Application for Removal or Variation of a Condition following Grant of Planning Permission or Listed Building Consent

Land off Station Road, Surfleet

Demolition of 180 Station Road, associated outbuildings, adjacent shed and erection of 7 two and three bed houses.

H17-0130-23

Proposed Block Plan
Scale 1:200

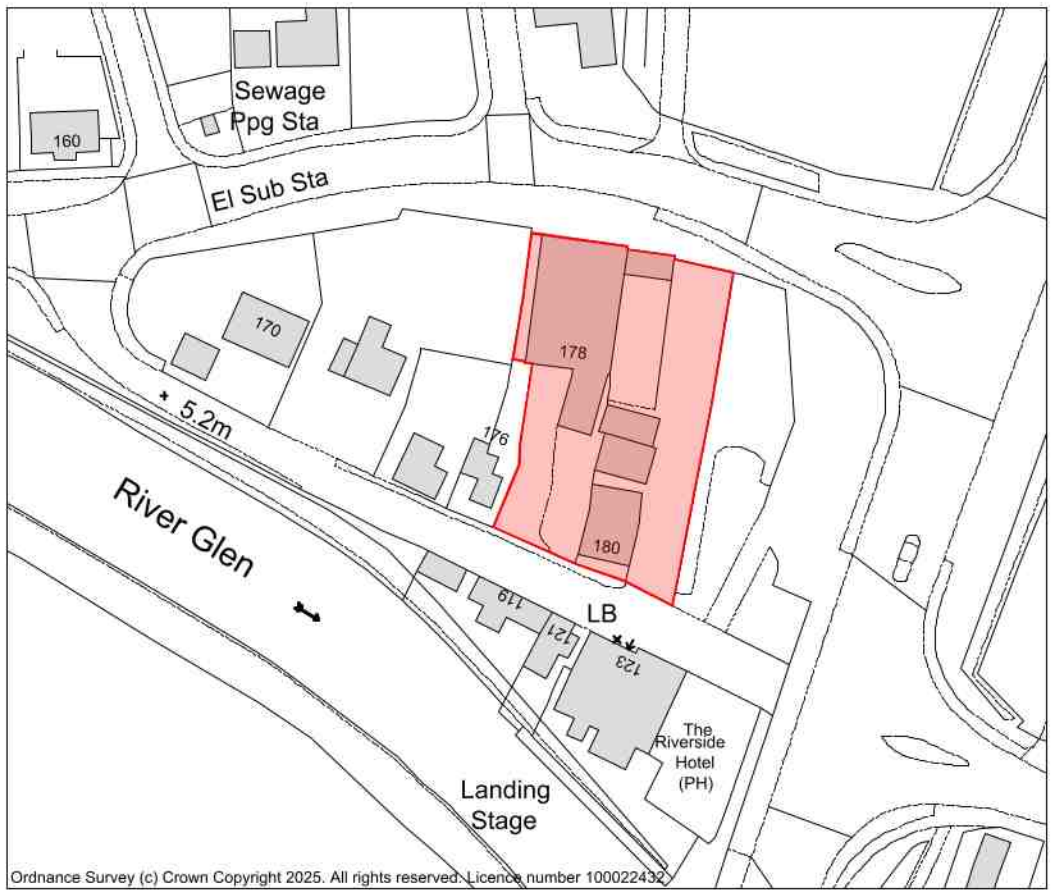
Condition 2 - Plots 4, 5, 6 & 7 are to be swapped so that plots 4 & 5 are the 3 bed house type and plots 6 & 7 are the two bed house type.
Condition 3 - The brick type has previously been approved as Vandersanden Bellona, this is to be amended to Forterra St Lawrence for all house types.
